bldc2018-00130

In Christian's absence, Rob Wiener and I have reviewed the window specs you've provided. Based on what we've seen, we have a few questions and conditions:

Historic brick building:

Rear Addition:

ELEVATIONS

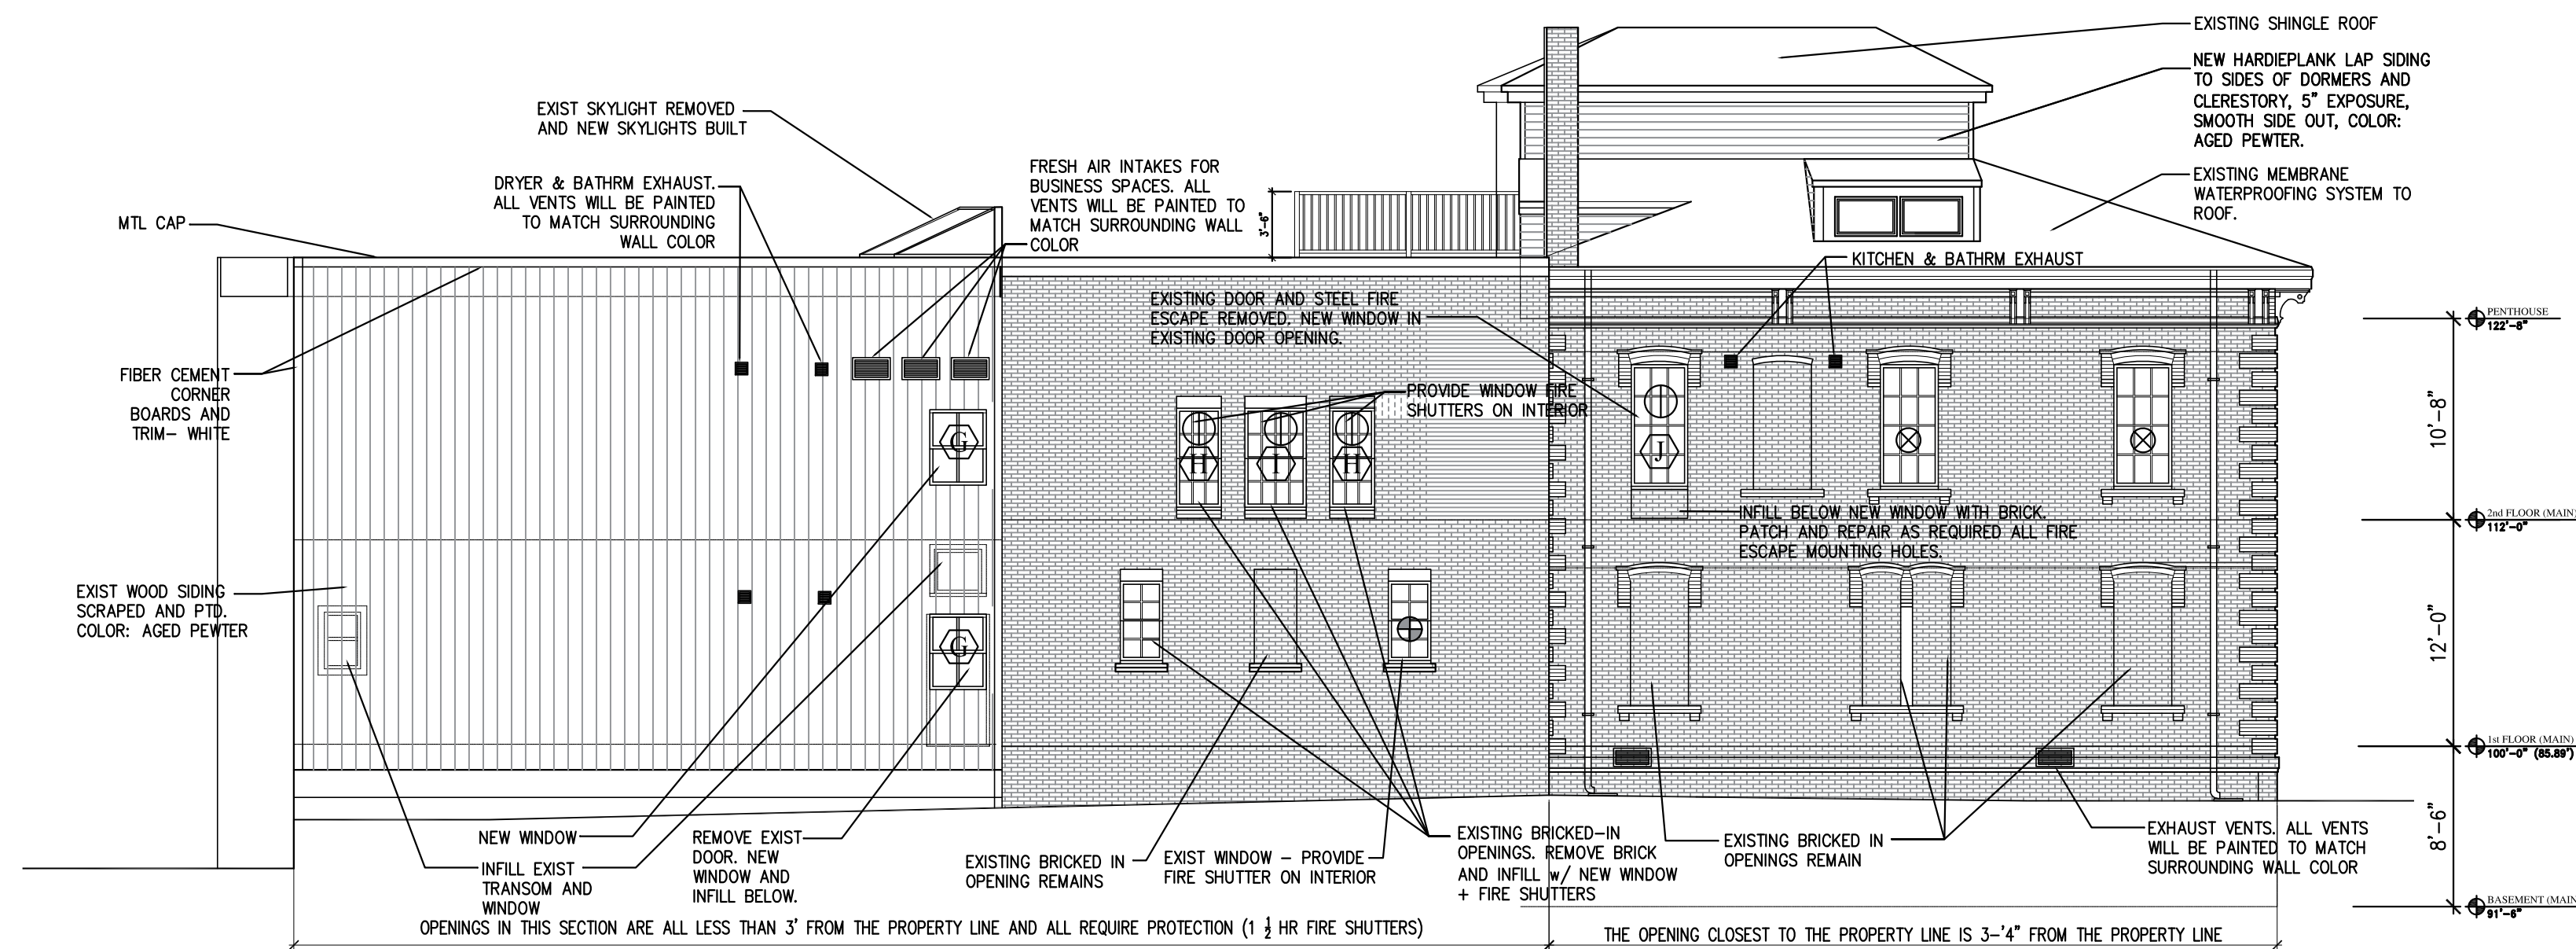
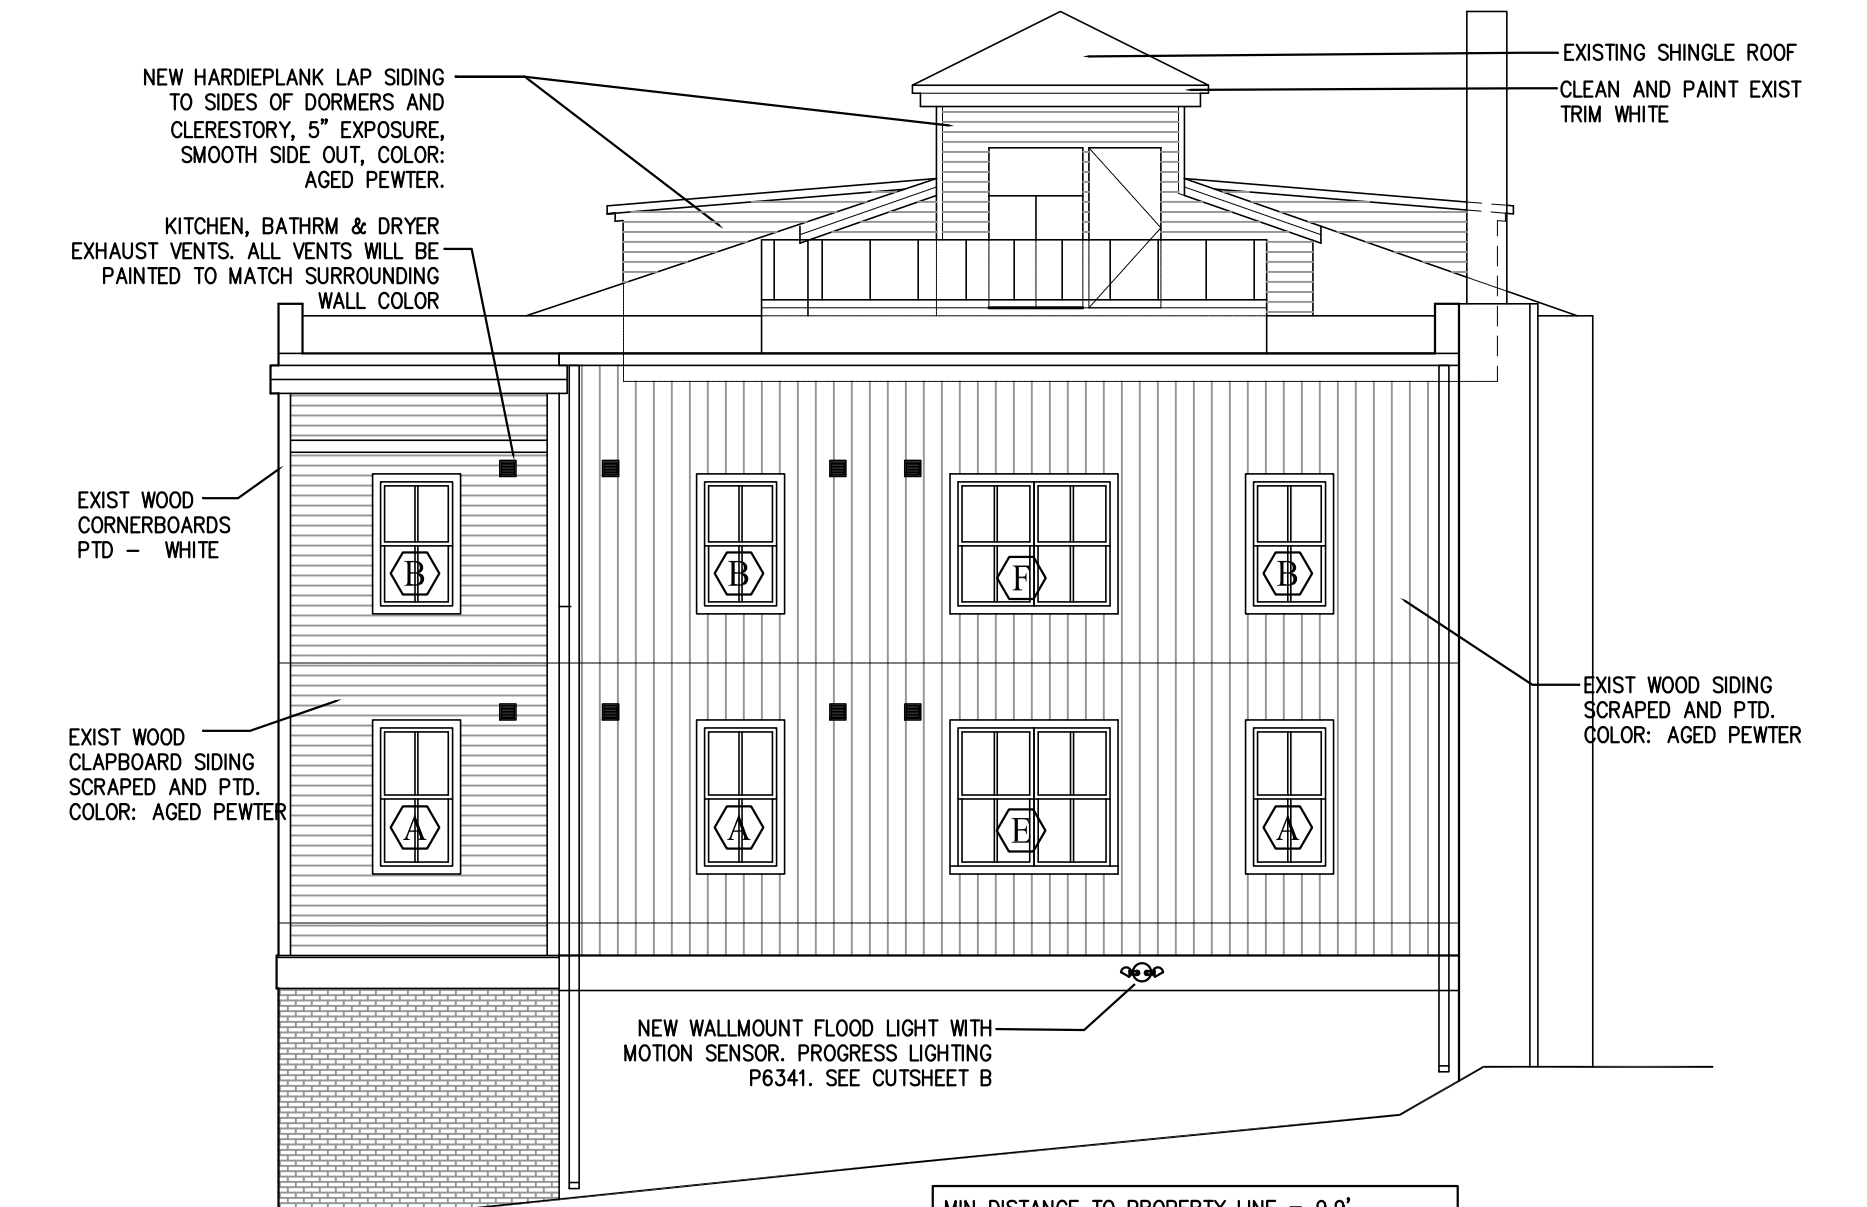
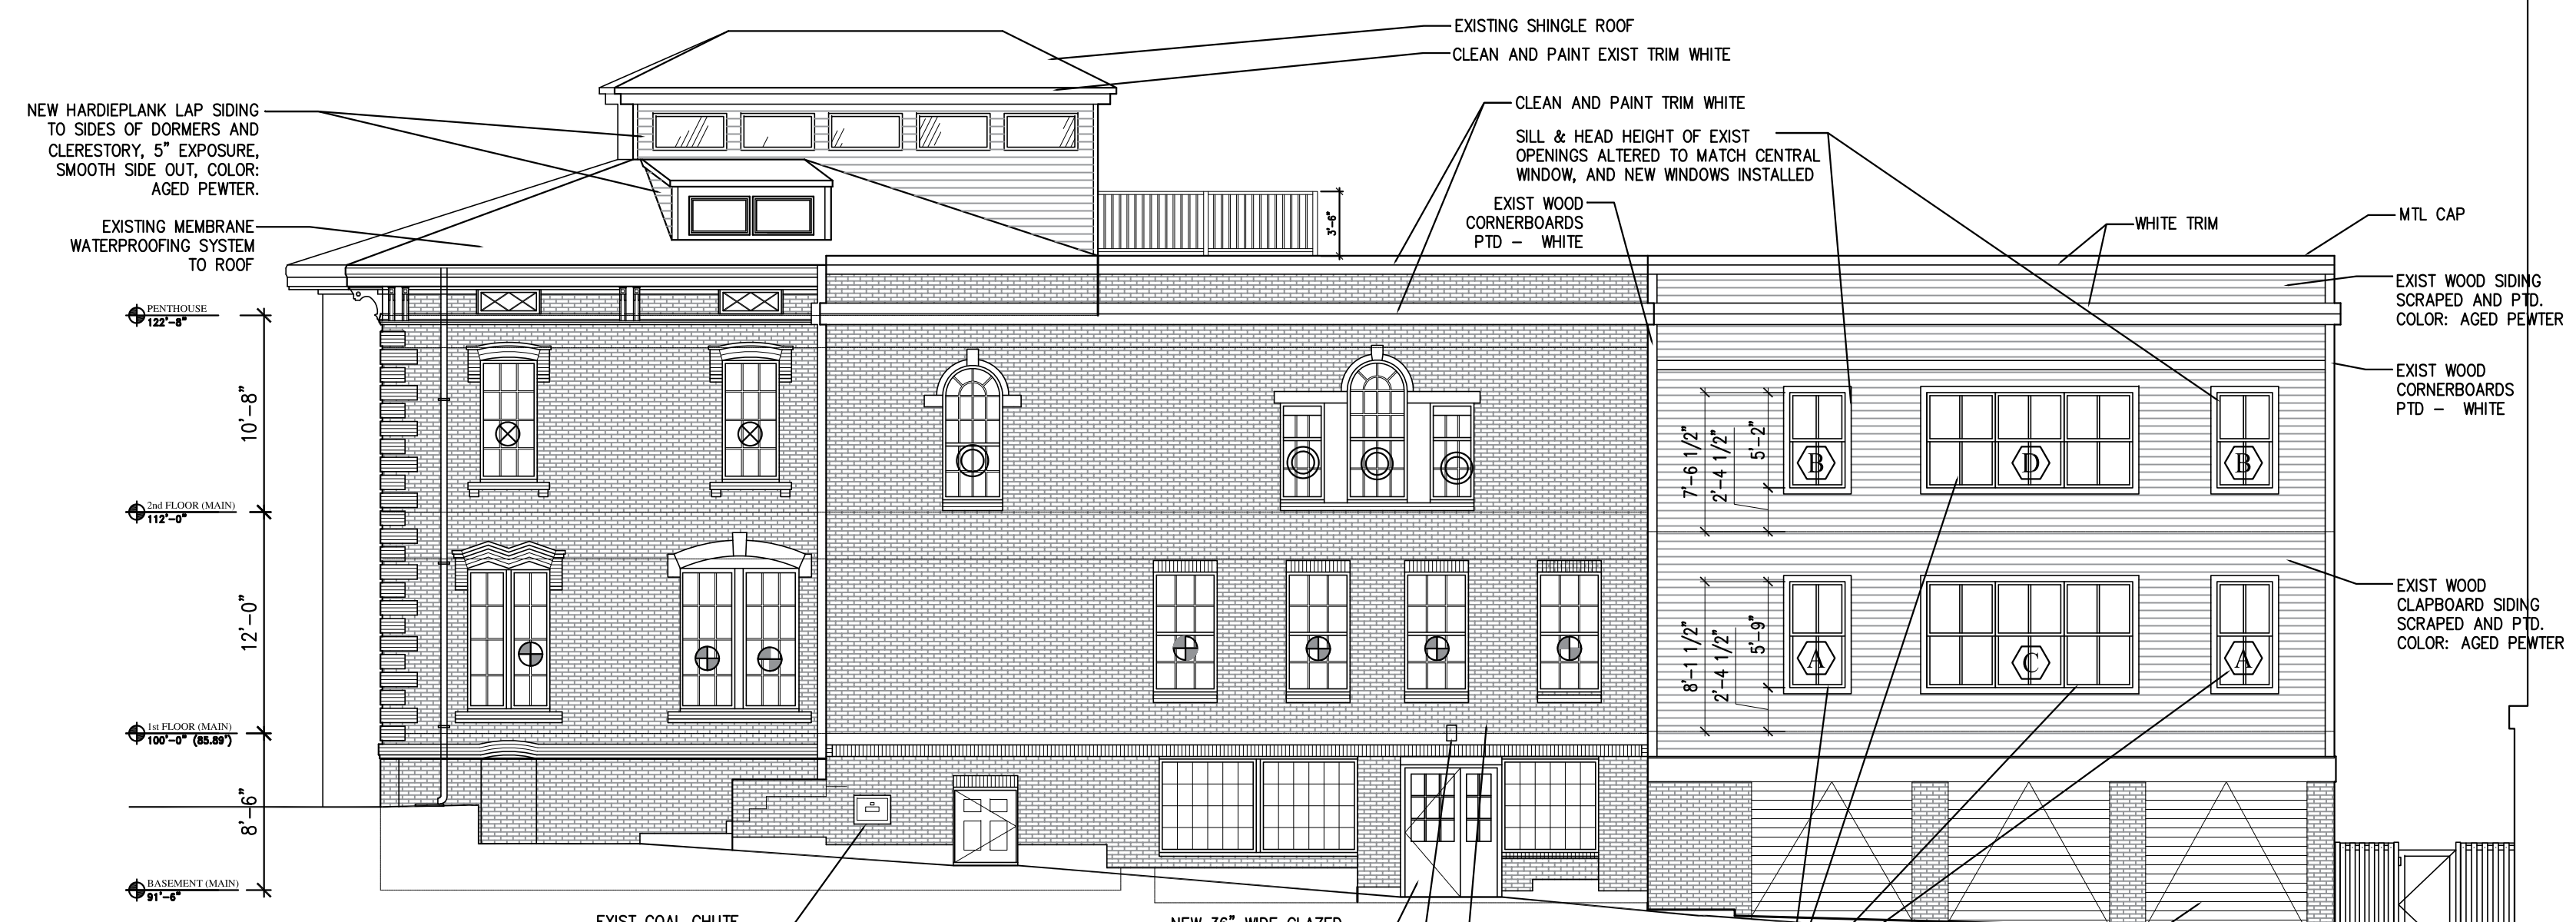
- 1) All windows in the historic structure should be ordered with half screens, not full screens.
- 2) Since you are replacing only some of the historic windows, it's important that the replacements match details of the existing windows to the greatest extent possible. For example, the new sash should be located at the same plane as the existing windows, not forward or back of this plane. Also, the brickmould (the trim that marks the transition between the windows and brick surround) needs to match the profile of the existing brickmoulds.

2) Since you are replacing only some of the historic windows, it's important that the replacements match details of the existing windows to the greatest extent possible. For example, the new sash should be located at the same plane as the existing windows, not forward or back of this plane. Also, the brickmould (the trim that marks the transition between the windows and brick surround) needs to match the profile of the existing brickmoulds. **The replica clad premium double hung windows will be installed in the opening in the same plane as the old windows, so there will be no difference.**

To that end, are you ordering windows with the casing or without casing? Are you applying brickmould trim in the field? Will there be more exposed casing than is now the case? These details need to be thought through, as the installation details will determine the success of the match. **We are going to salvage as much of the existing brick mold as possible and replicate as needed. We will field apply.**

1) All windows in the historic structure should be ordered with half screens, not full screens. **Understood. Half Screens will be ordered.**

2 | FOREST AVENUE ELEVATION
1/8" = 1'-0"

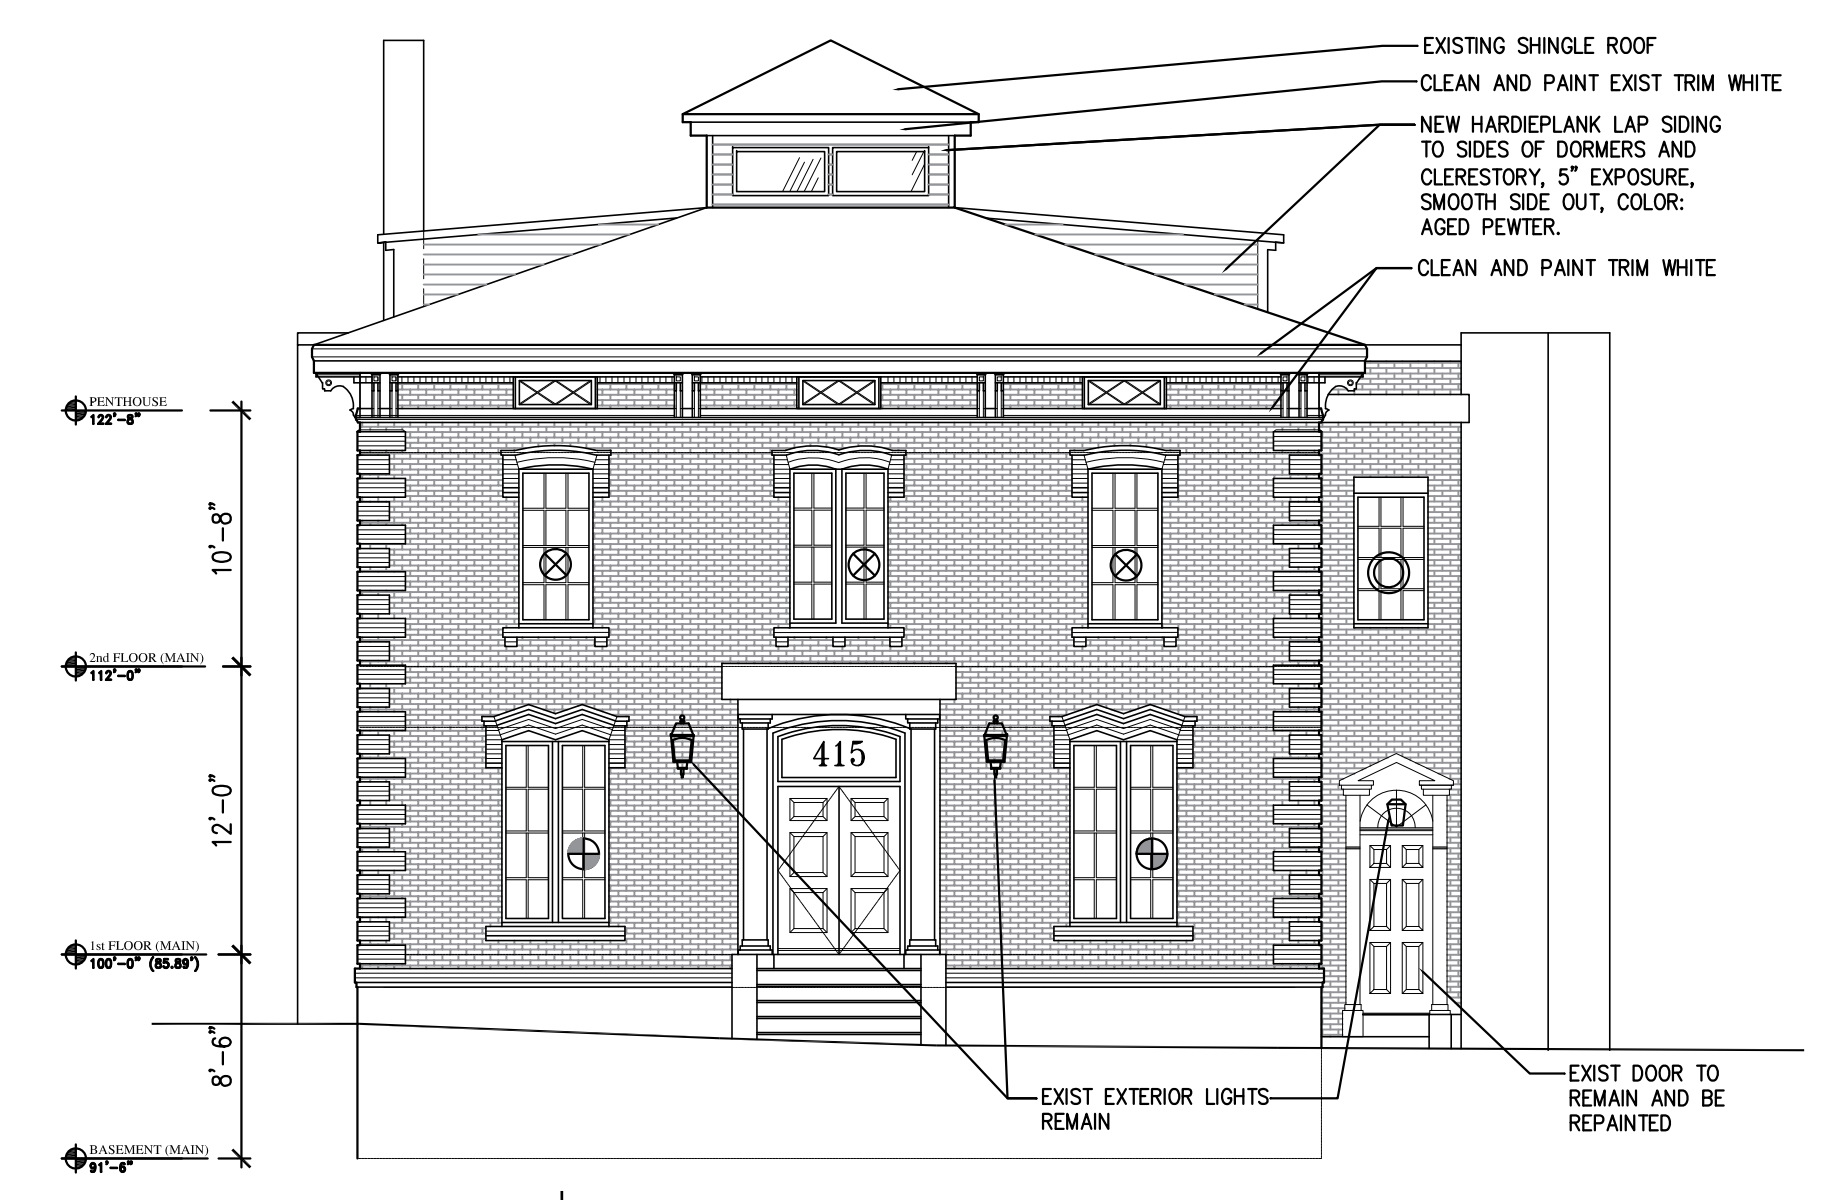
3) Will the large window openings on the Forest Ave elevation be infilled with three individual windows separated by mullions or are you ordering a single 3-part window? This is difficult to tell from the latest elevation. **We are ordering 3 separate windows to be mullied in the field.**
